CITY OF ALBUQUERQUE

September 5, 2012

**Re: Boulders Phase I and II
Grading and Drainage Plan
Engineer's Stamp Date 8/28/2012 (B11/D001C)**

THE BOULDERS SUBDIVISION PHASE TWO DRAINAGE BASINS

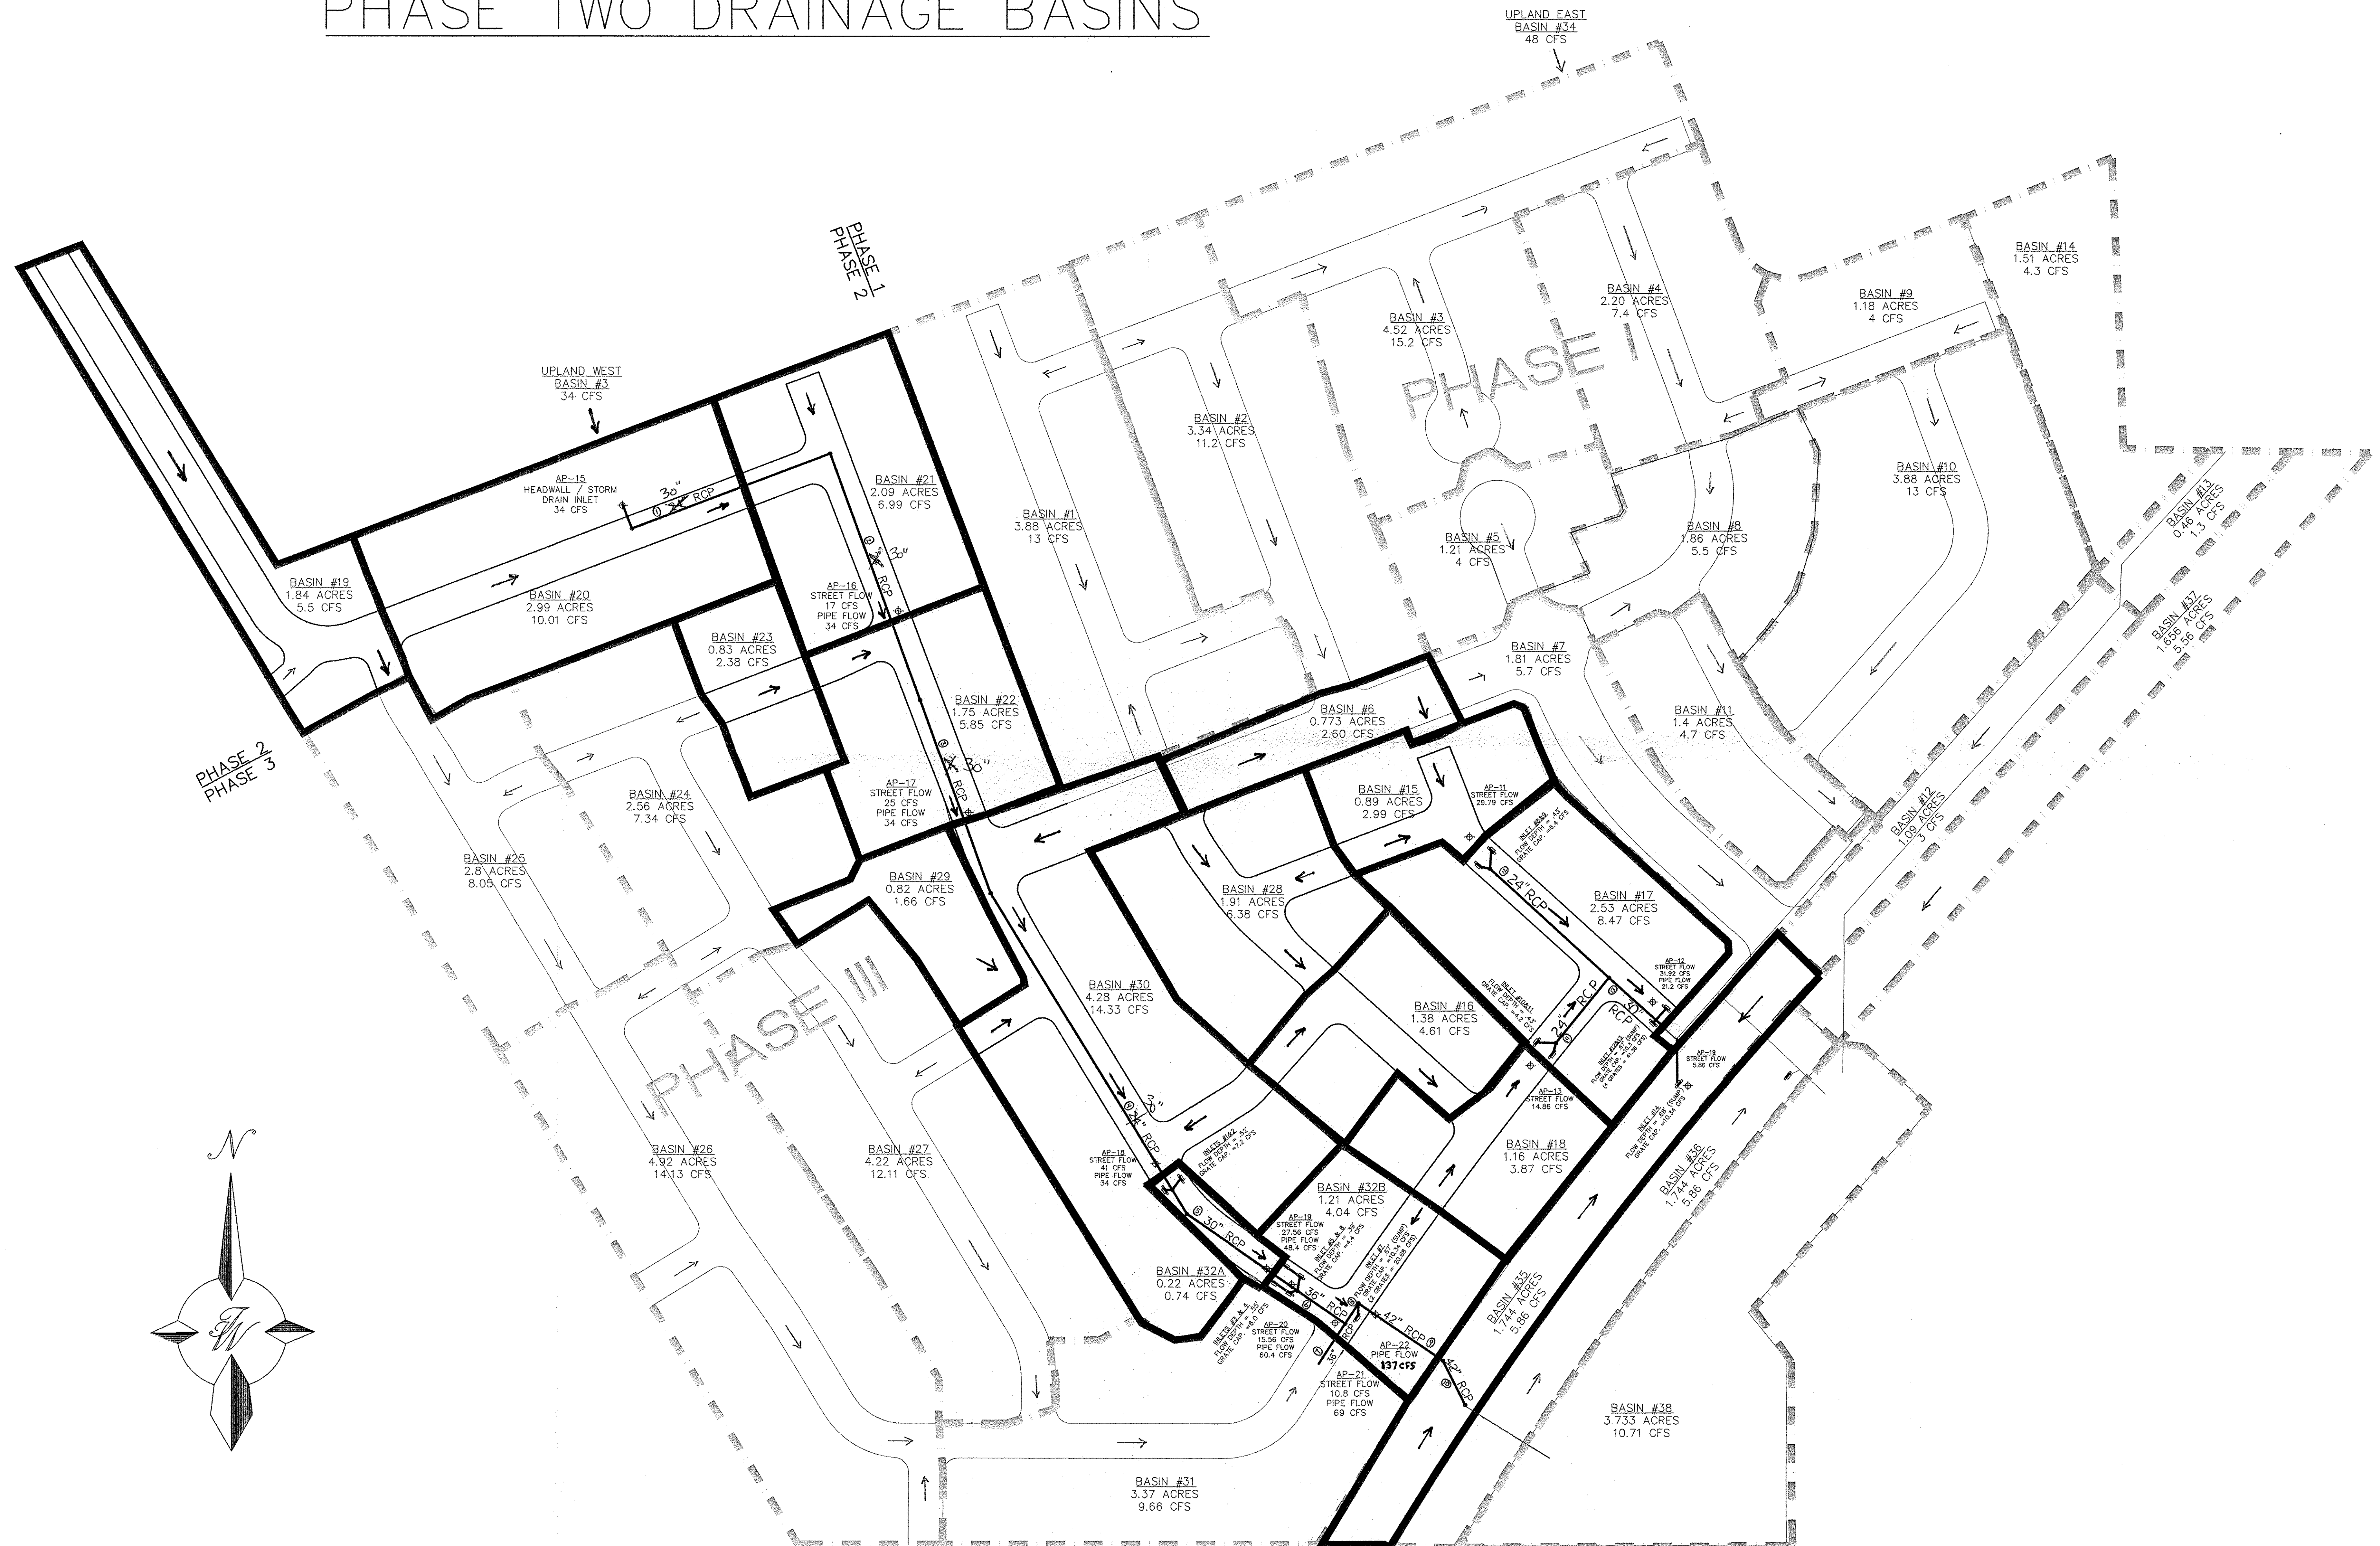
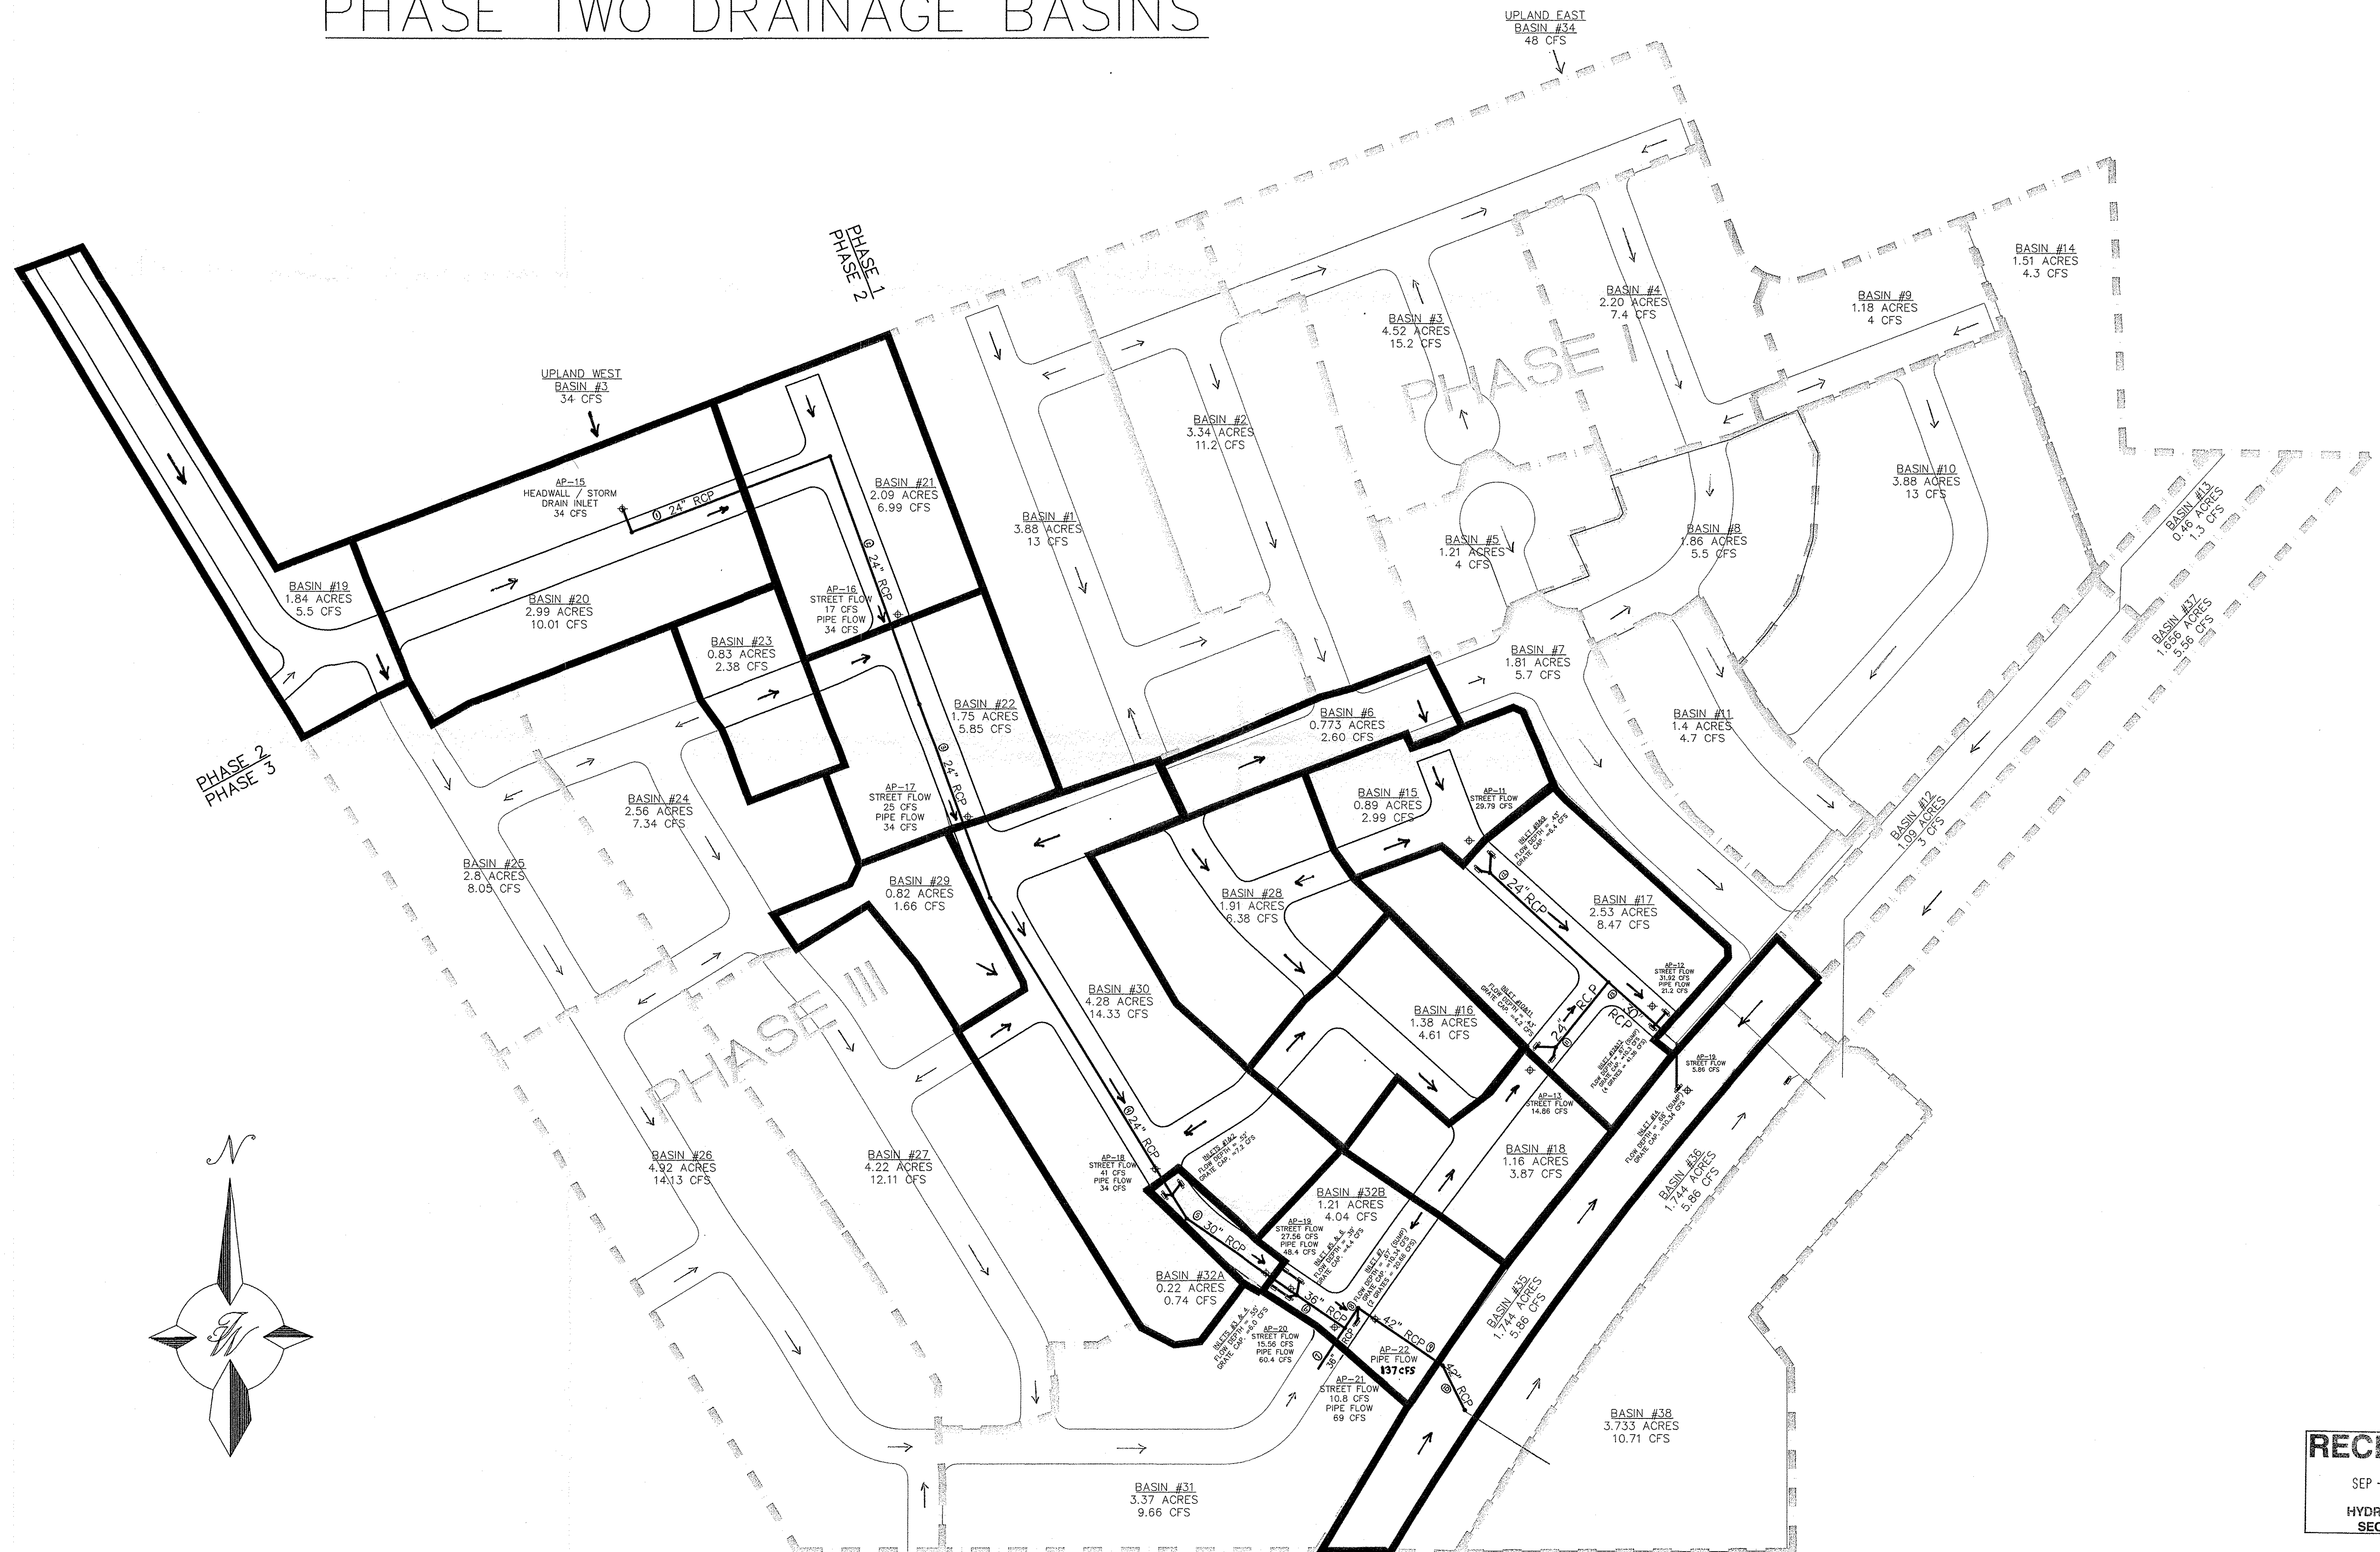
- Provide the AHYMO output file for ultimate conditions of the proposed detention pond, pond calculations, and overall basin map.
